East Anglia ONE North and East Anglia TWO Offshore Windfarms

Applicants' Responses to Examining Authority's Written Questions

Volume 12 – 1.10 Landscape and Visual Impact

Document Reference: ExA.WQ-1.D1.V1_12

Figure: 29.13e
Viewpoint 1: Public Right of Way near Friston House

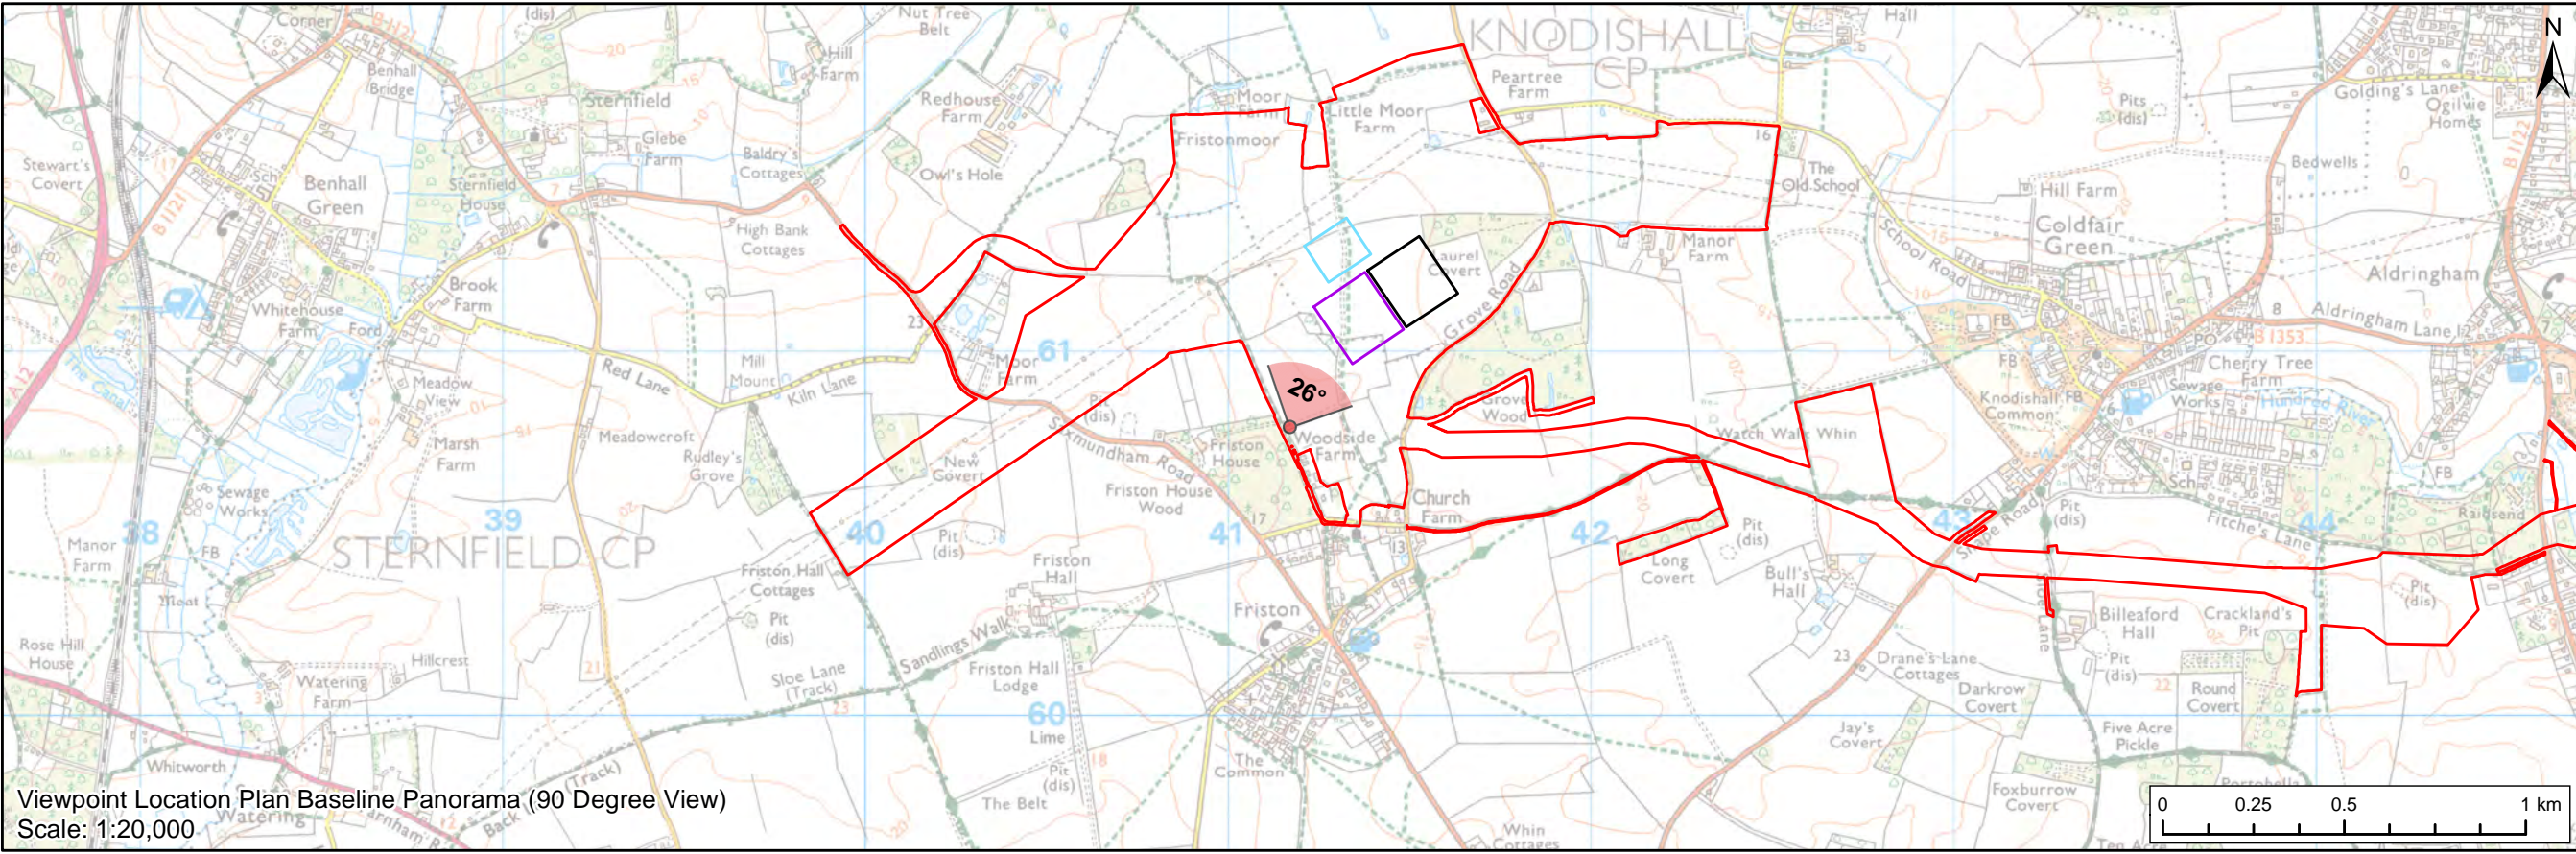
1.10.2	Any IP and the Applicant	1	<p>2 A number of RRs raise concerns about the visual impact of development on Friston, with reference to the adequacy of mitigation.</p> <p>Is further mitigation required and what form might this take? Would additional planting of trees and hedgerows be an appropriate method to resolve this? What form might additional planting take?</p>	<p>The Applicants note concerns about the visual impact of development on Friston. The Applicants would highlight that these visual effects principally occur on receptors in a limited area on the northern edge of Friston (Church Road area) and the PRow leading north out of the village, and to a lesser degree from the main area of the settlement developed slightly to the south from the church in the triangular shape of an infilled green. This main area of Friston is set back at greater distance from the onshore infrastructure than the dispersed northern edge of the village, separated by the village green (Viewpoint 6 – Figure 28.18a-e), areas of common land around St Mary's Church, modern housing on Church Road / Hillcrest and Friston House Wood and the</p>

ExA. Question Ref.	Question addressed to	ExA. Question	Applicants' Response
			<p>Saxmundham-Aldeburgh Road (B1121) (Figure 29.21a-e).</p> <p>The Applicants note the potential to provide further mitigation of the visual effects of the onshore substations in views from the northern edge of Friston, such as VP2 (Figure 29.14 (APP-405)). The Applicants considers that the form of this mitigation could include:</p> <ul style="list-style-type: none"> • Additional planting of field boundary trees and hedgerows; • Additional 'covert' woodland block/belt planting at closer proximity to VP2 / Friston; and/or • Subject to the availability of suitable material onsite, formation of soil formed earthworks to raise ground level contours in the area to the south of the onshore substations. <p>The Applicants considers that in order for the visual effects to be notably reduced, or potentially avoided, over the long-term, more substantial woodland planting at closer proximity to Friston, as represented in VP2 (Figure 29.14 (APP-405)), would be required. This could potentially take the form of 'covert' woodland blocks planted at strategic locations, or a more continuous woodland belt planting along the closest field boundary to the north of Church Road / the PRoW, visible in VP2 (Figure 29.14 (APP-405))</p>

ExA. Question Ref.	Question addressed to	ExA. Question	Applicants' Response
			<p>(rather than individual field boundary trees, as currently proposed). The former approach was proposed in the earlier drafts of the OLMP at Preliminary Environmental Information Report (PEIR) (PEIR Figure 29.11), however the landscape proposals evolved following PEIR in consultation with stakeholders to move the planting further north, to avoid such close-up planting, on the basis of preference to maintain the open agricultural setting of the village and its historical setting. The Applicants consider that additional planting of this form would be an appropriate method to further mitigate the visual impact of the onshore substations in views from the northern edge of Friston, while accepting that this approach may have an impact in itself in changing the 'open' landscape character and the historic setting of the village. On balance, and based on consultation feedback, the Applicants preferred the retention and enhancement of character, but recognise others may have different view. The Applicants have proposed the acquisition of sufficient land to provide this additional planting and if this were to be preferred, it could be required through the approval of the LMP.</p> <p>The Applicants consider that there is also potential for further mitigation through the formation of soil formed earthworks (i.e.</p>

ExA. Question Ref.	Question addressed to	ExA. Question		Applicants' Response
				<p>'bundling') to raise ground level contours in certain areas to the immediate south of the onshore substations, potentially to coincide with woodland planted areas, in order to provide further visual screening and increase the height of tree screening above existing ground levels although note that (to avoid transportation of material to site) this is subject to the availability of subsoil and top soil from the substation construction.</p> <p>It is noted that an updated OLMP General Arrangement (APP-401) will be submitted to Examination at Deadline 3.</p>
